# Longfield Solar Farm

Statement of Common Ground – Environment Agency

Document Reference: EN010118/EX/8.4(B)

November 2022

Figure 9-2b

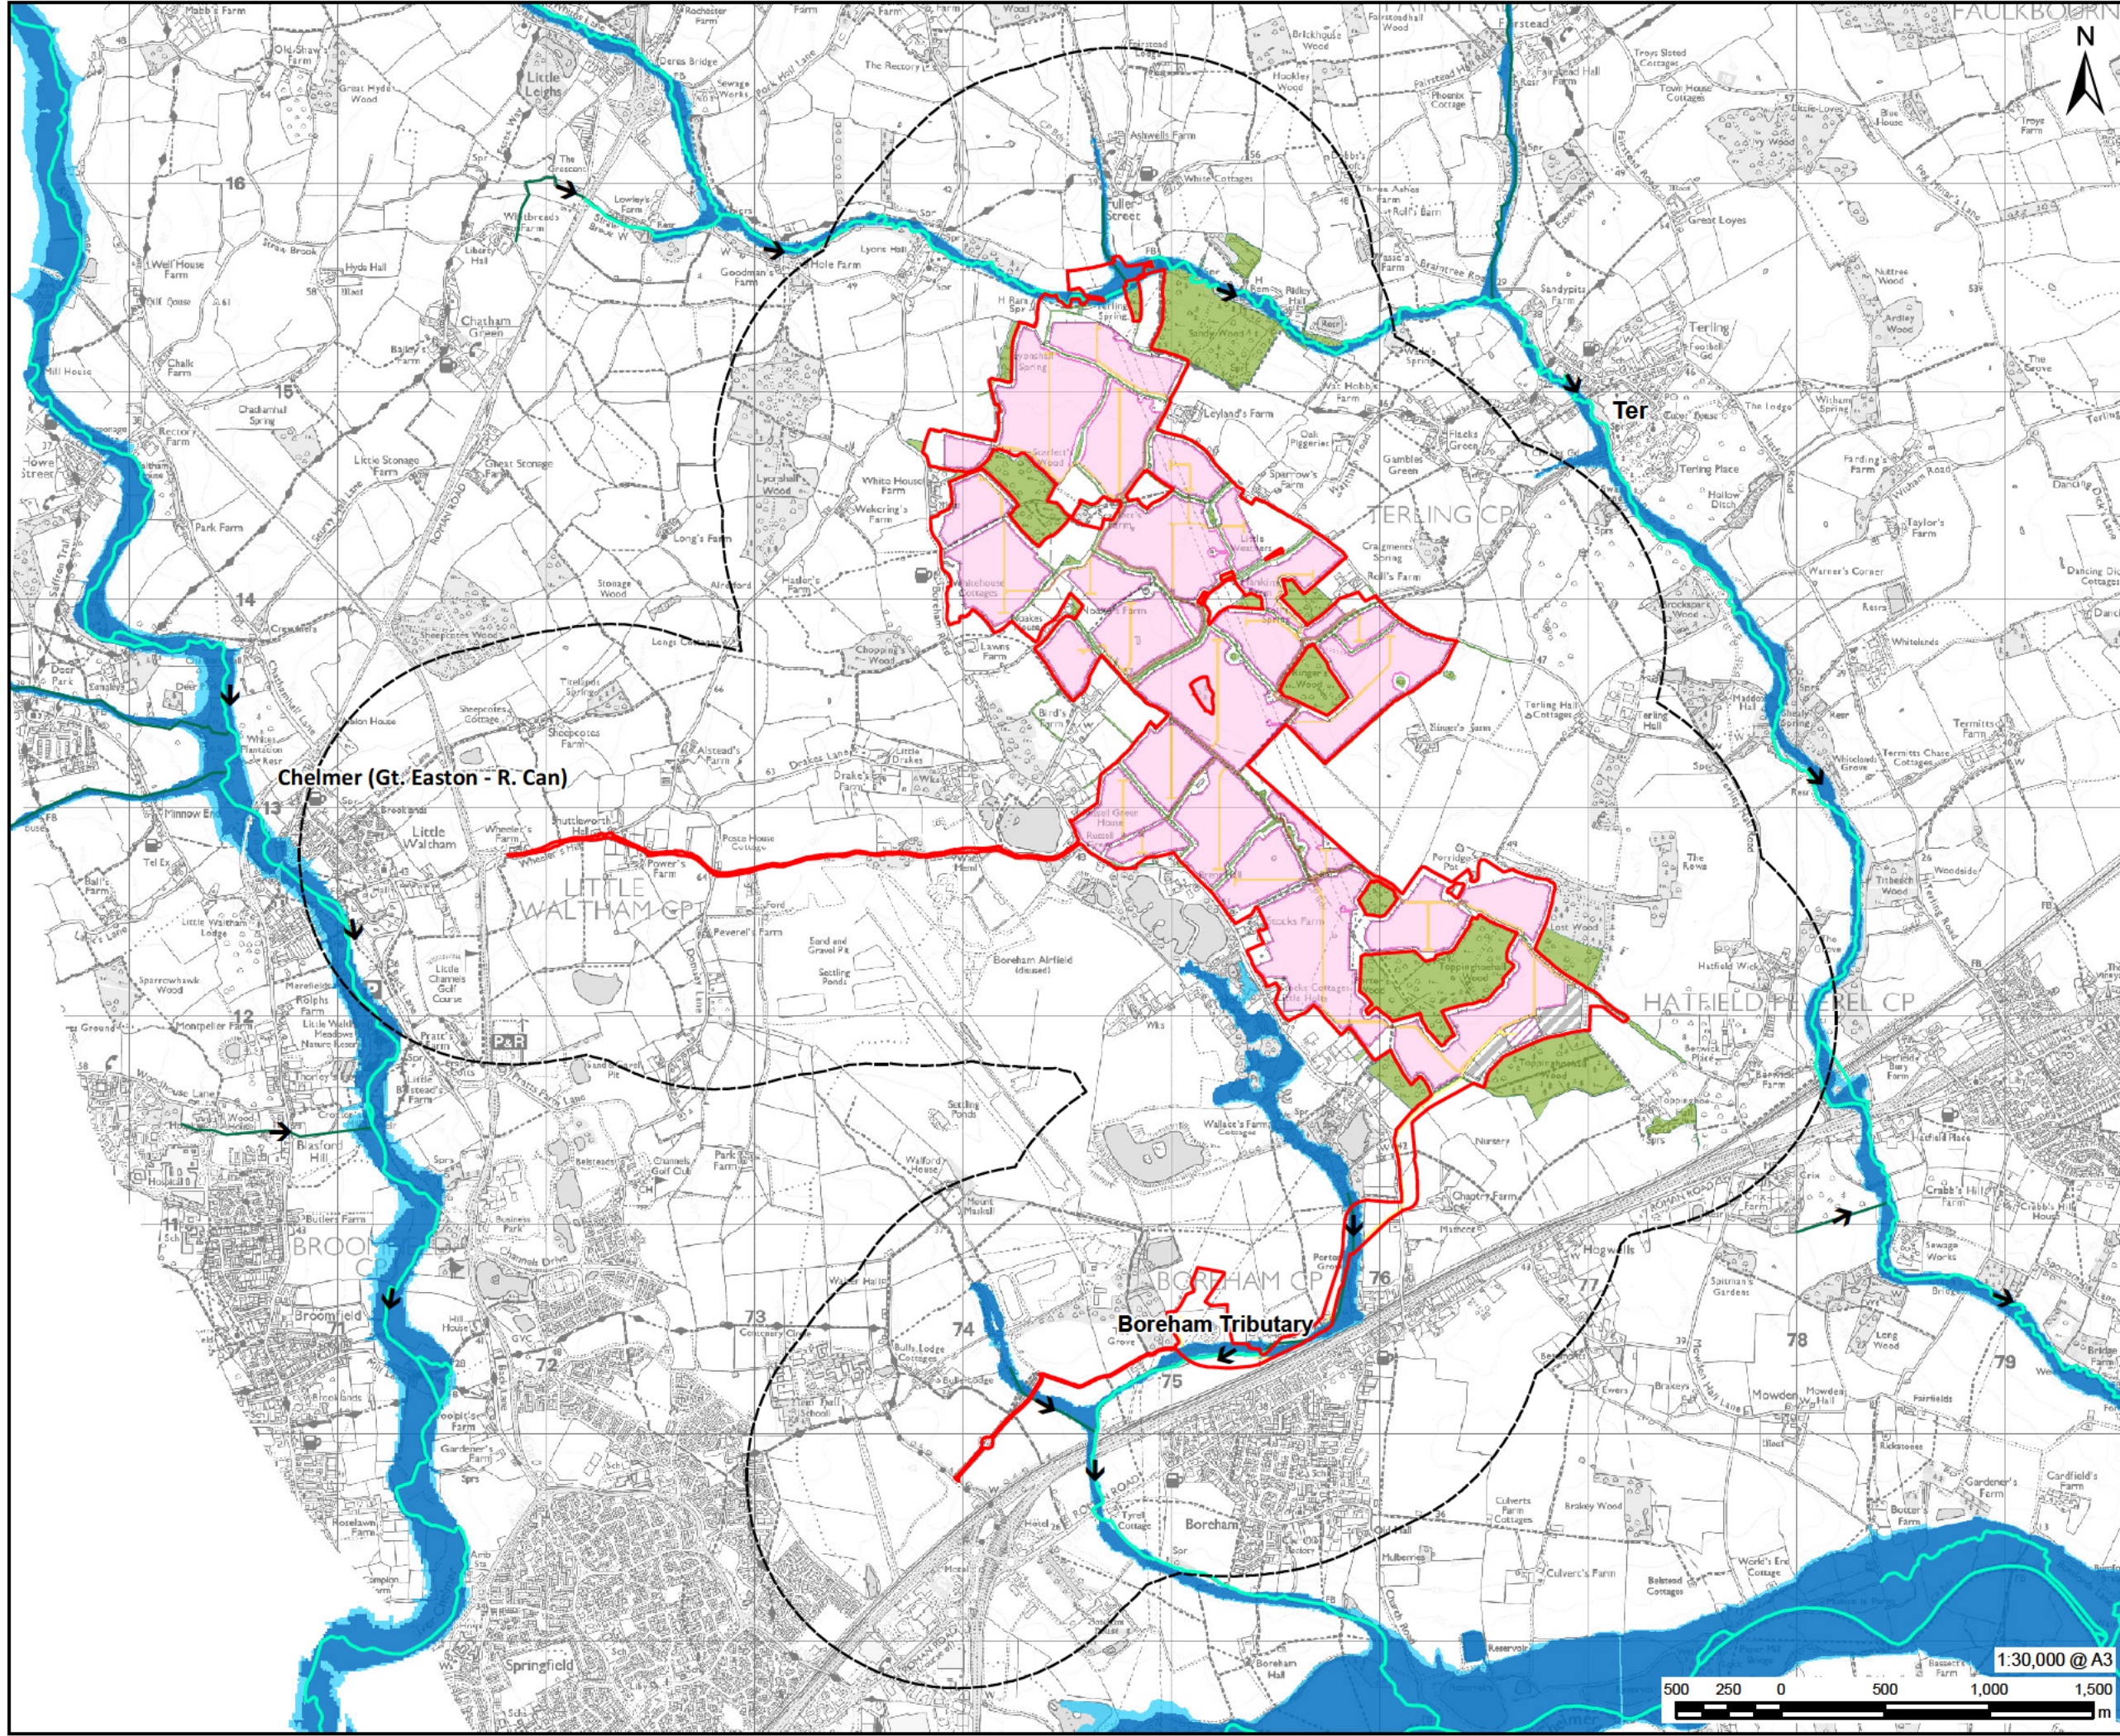
12	<b>Development areas and Flood Zones</b>	Appendix A of the FRA shows the layout of the development. It should also have a map showing built development in relation to the flood zones (including climate change, for the lifetime of development and beyond, as a sensitivity test). [Statutory consultation]	The updated FRA is available in <b>Appendix 9A Flood Risk Assessment [EN010118/APP/6.2]</b> . Figure 3 shows areas where above ground development may be located in relation to Flood Zones.	<b>Agreed</b>
